Application No: FG/94/20/HH
Site Address: 7 Little Drive Ferring BN12 5RF
Description of works: Conversion of roofspace to habitable use and conversion of roof from hip to gable end and single storey rear extension.

Thank you for your internet representation made on 23rd September 2020 which has been recorded as an objection with the comments as follows:

FIRST FLOOR PLAN.

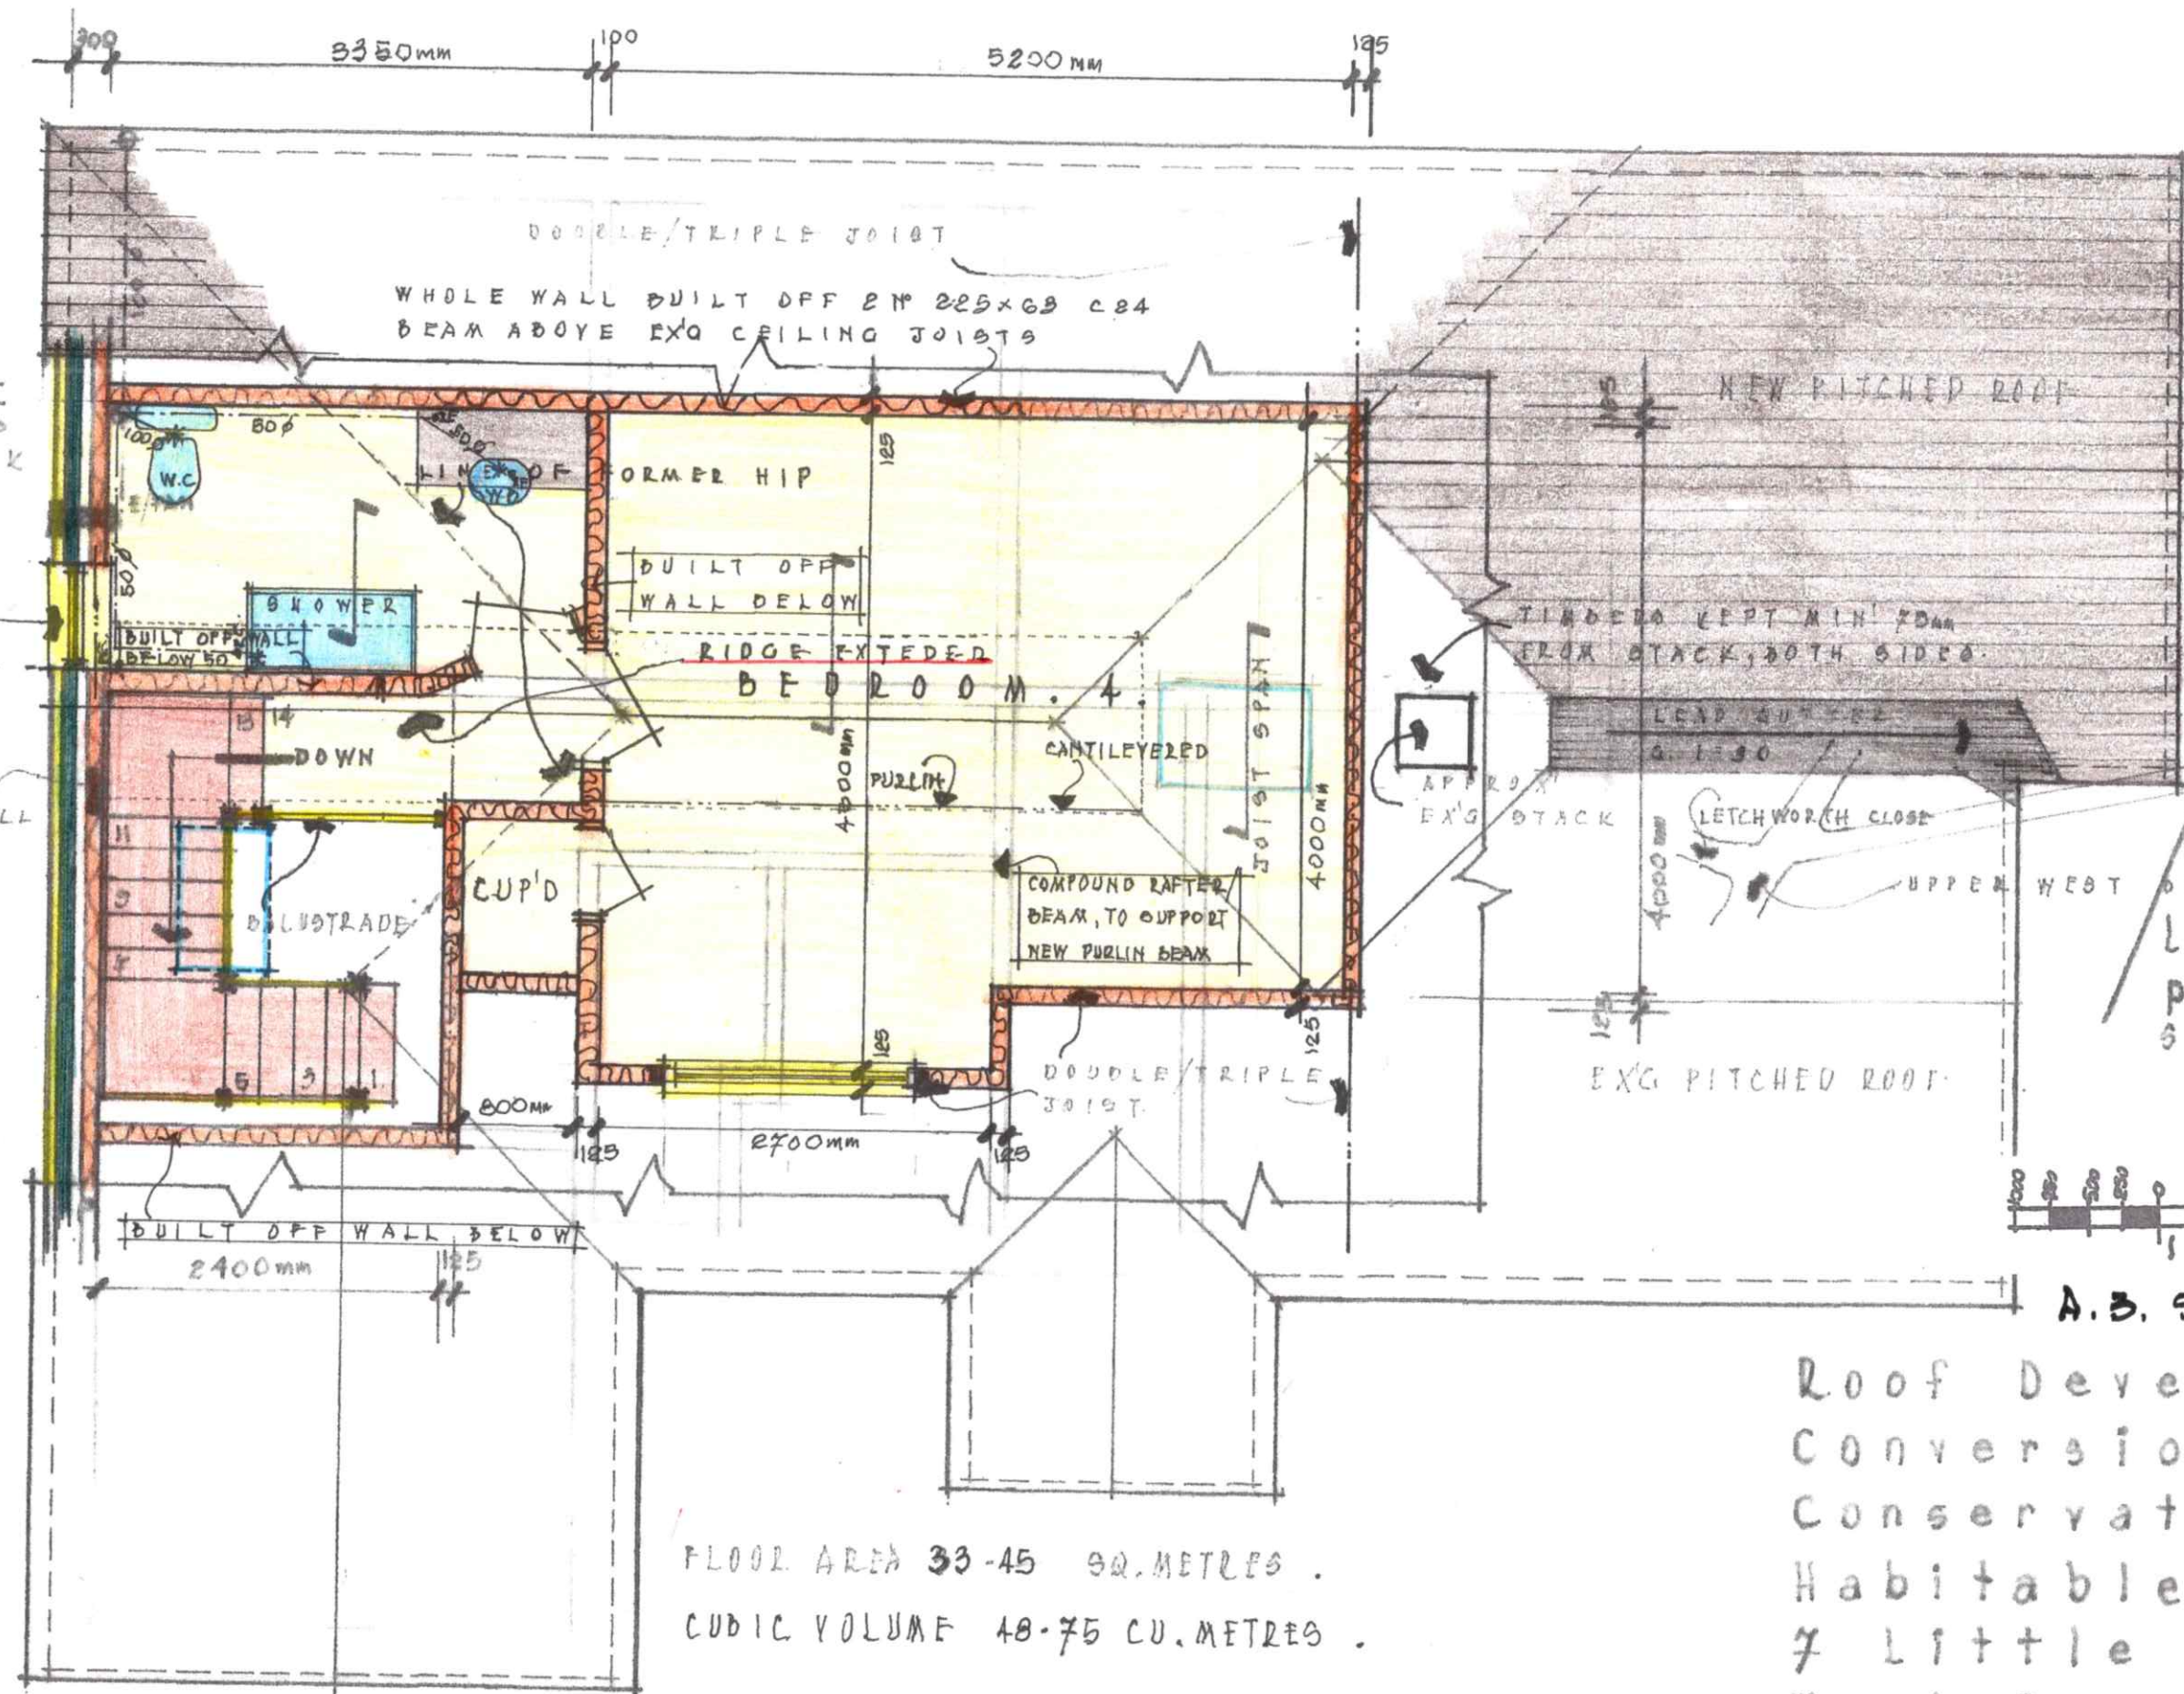
The large dormer window and velux window in the gable end roof extension will overlook mine and neighbouring properties which will impact greatly on our privacy.
